Subject: LU/274/21/DOC - 2 Croft Cottages, Pier Road, Littlehampton, BN17 5LS

In reference to the above application to discharge condition 9 of LU/159/19/PL at the above site and having reviewed Your Environment's Phase 2: Site Investigation Report (ref.: YEX1975, dated April 2021), whilst the majority of the content appears satisfactory, it is not possible to provide a formal response until appendices A-E have been assessed; please may these be provided as I cannot find them on the portal.

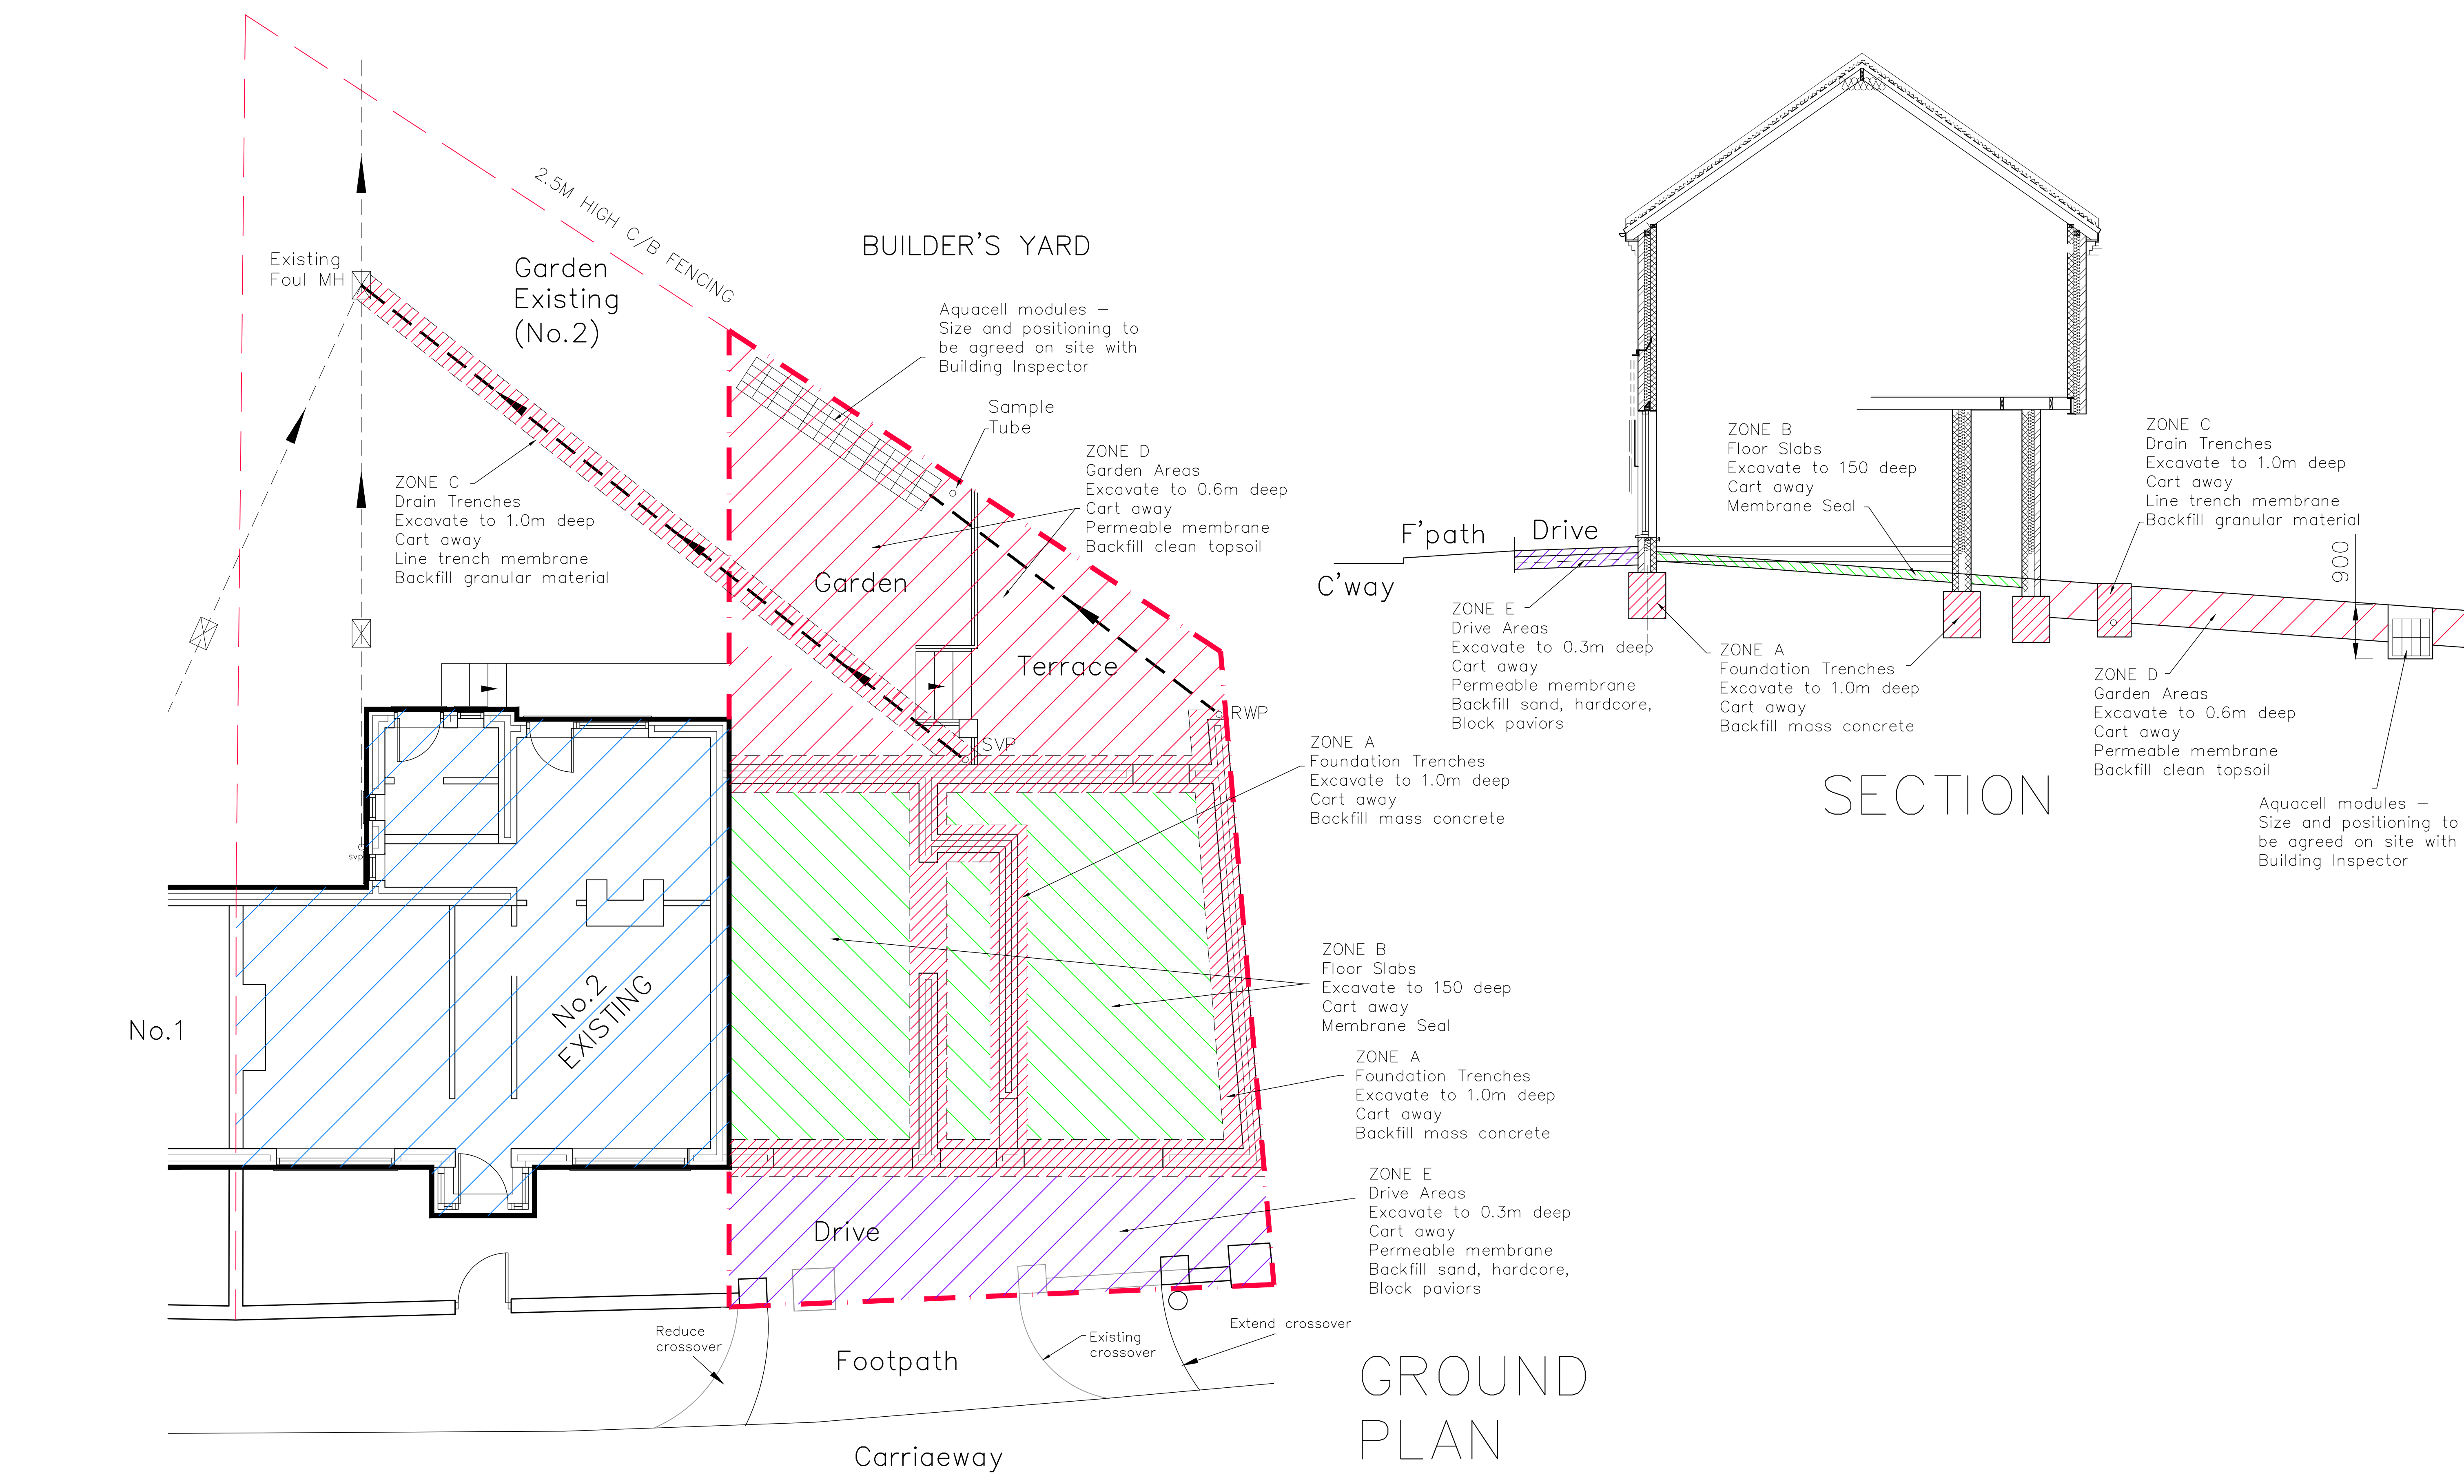
Notwithstanding the above request for information, it is unclear whether the Aquacell modules as depicted on Critchley Architecture and Design Ltd.'s Proposed Contamination Containment plan (rev. A, dated August 2021) are soakaways – please may this be clarified as this may contradict the Environment Agency's recommendations of not installing such structures in made ground/contaminated land.
